## *Lancashire Gardens Trust*

**Proposed demolition of existing dwelling, erection of replacement two storey four bedroom self build dwelling with detached double garage and associated works. Application 3/2024/0745.**

**Avenue Farm, Avenue Road, Hurst Green BB7 9QB. JCNAS Ref 199360.**

Scale 1:1250	Job Number 24-016	First Issue SEPT_24
Sheet A4	Author	Drawing Number PL01

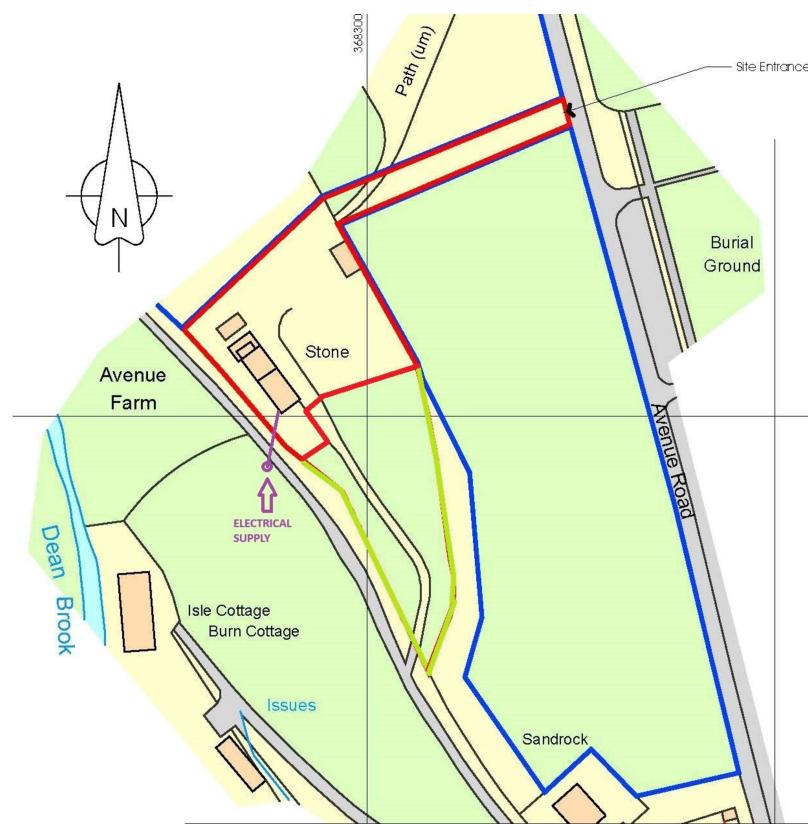
The screening woodland appears from the location plan blue line to be within the applicant's ownership. It is a concern that the ownership of the RPG is becoming subdivided. We understand that the woodland is not within a conservation area and may not be covered by a TPO. This issue needs to be addressed in the conditions attached to any approval, to ensure that any management or other works to the woodland are controlled and regulated through planning.
